Reference No:	2022/62/92901/E
Site Address:	85, Marsh Lane, Shepley, Huddersfield, HD8 8AP
Description:	Demolition of existing garage and outbuilding and erection of garage with living accommodation ancillary to No.85 Marsh Lane [within a Conservation Area]
Recommending Officer:	Nina Sayers

DECISION - REFUSED

Officer Report

Drawing Title
PROPOSED FLOOR PLANS
AND ELEVATIONS

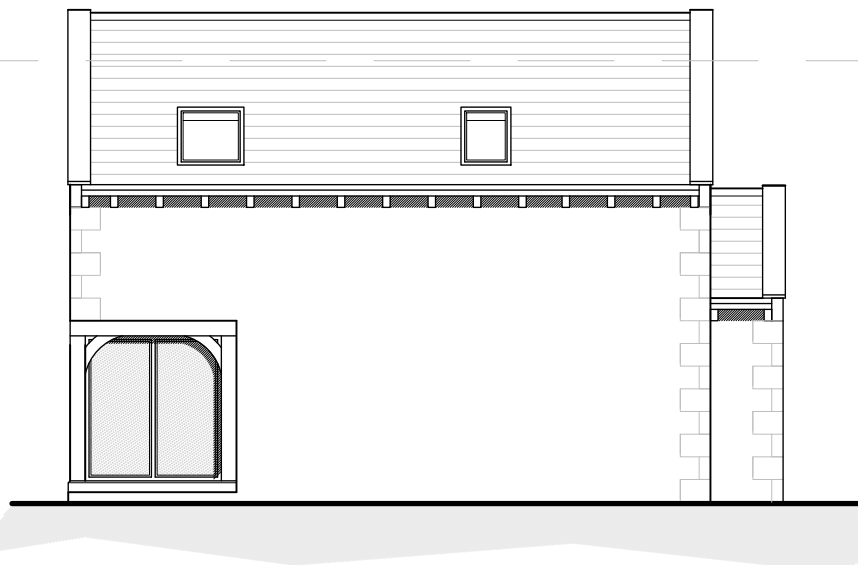
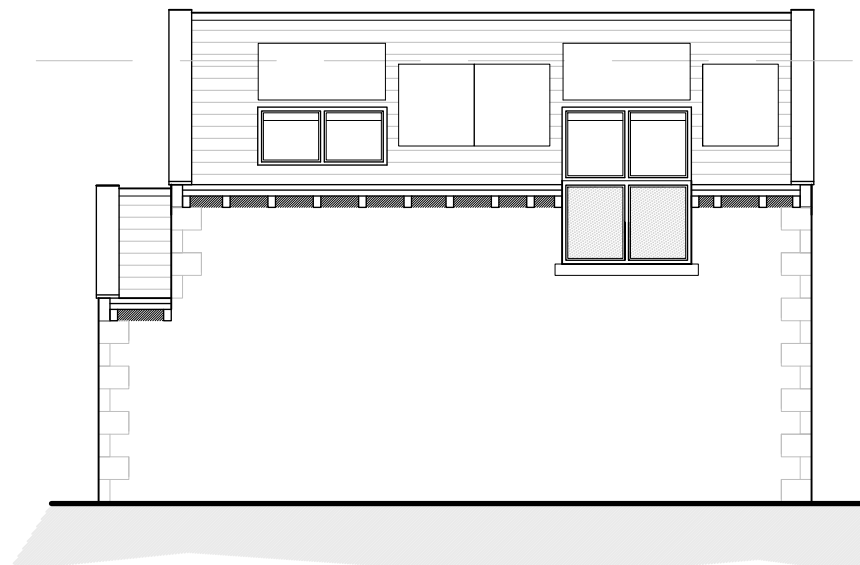
The proposed garage is located the southwest of the host dwelling sitting behind the rear elevation of the host dwelling. The proposed would have a similar footprint to the original dwelling, prior to extensions, and to other properties within the street scene. Whilst it would be set down 2 metres from the roof ridge of the original house, the proposal would still appear large in scale in relation to the surrounding development. Taking this into consideration, the proposed development would not be considered subservient to the host dwelling. The proposal would not be in keeping with the character of the surrounding area in terms of scale or design, relating poorly to nearby development, appearing incongruous within the wider character of the area.

1. Due to the scale and design of the development proposed it would appear disproportionate to the host building and obtrusive within the site, detrimental to visual amenity and contrary to Policy LP24 of the Kirklees Local Plan, Key Design Principles 1 and 2 of the House Extensions and Alterations SPD and the aims of the National Planning Policy Framework.
